From: [REDACTED]
Sent: 02 June 2020 16:59
To: Anita Gardner <Anita.Gardner@arun.gov.uk>
Cc: 'Shivani Bhardwaj' [REDACTED]; 'Andrew Burns' [REDACTED]; Richard Work [REDACTED]
Subject: RE: A/50/20/PL Variation of Condition application - Pound Place

Subject: A/50/20/PL Variation of Condition application - Pound Place

SOUTH ELEVATION TO NORTHERN BOUNDARY

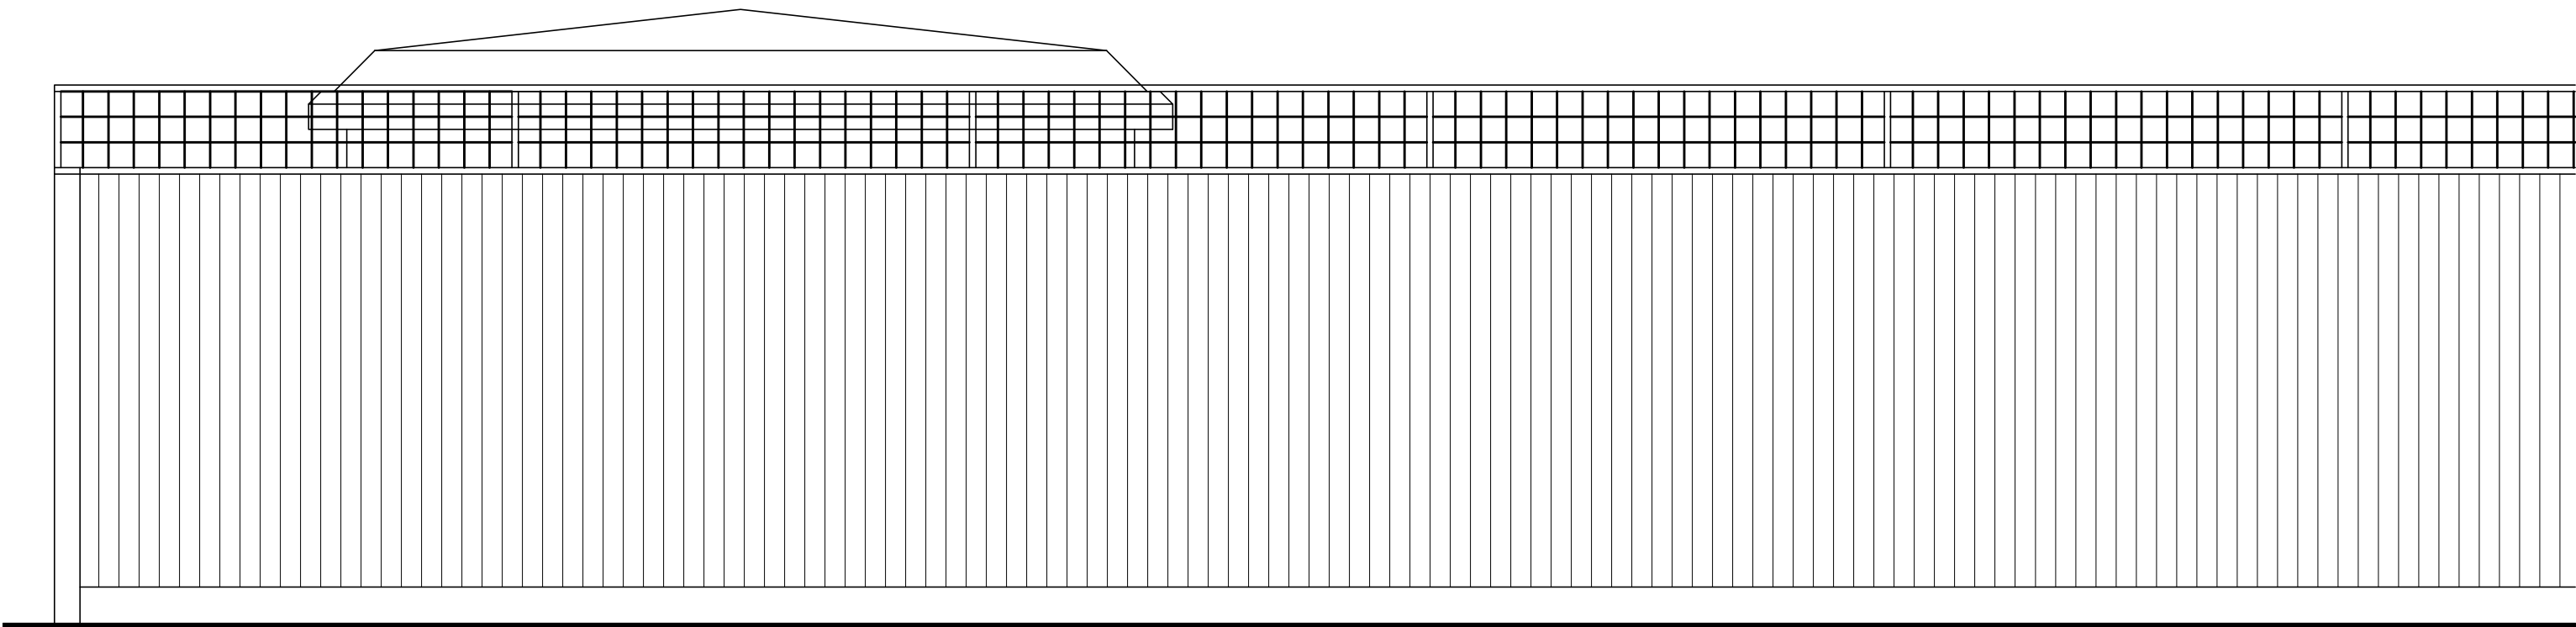
I have started to look at the above application in detail and notice that the drawing entitled Unit and Padmount Substation in a GRP Enclosure EDS-07-3102.01 rev C is incorrect. The Plan view of Site and Equipment refers to back edge of public footpath and the shape of the structure does not seem to accord with the block plan. Can you provide more precise layout details and clearly annotated elevations so that it is clear what elements of the structure are meter housing and generator and what will be visible from no2 adjoining the site and Roundstone Lane. I would also appreciate a street scene detailing the relationship and height of the structure in relation to the boundary with no 2 and proposed planting with a dimensioned distance from the boundary. Is there any opportunity to move the structure further from the site boundary to reduce the impact on the neighbouring property?

The site boundary elevation, boundary plan and general arrangement plan have a 300mm trellis to the top of the 1800mm timber fence as requested by the owners of the adjoining houses. The elevation does not show any planting as there is none proposed between the substation and the fence.
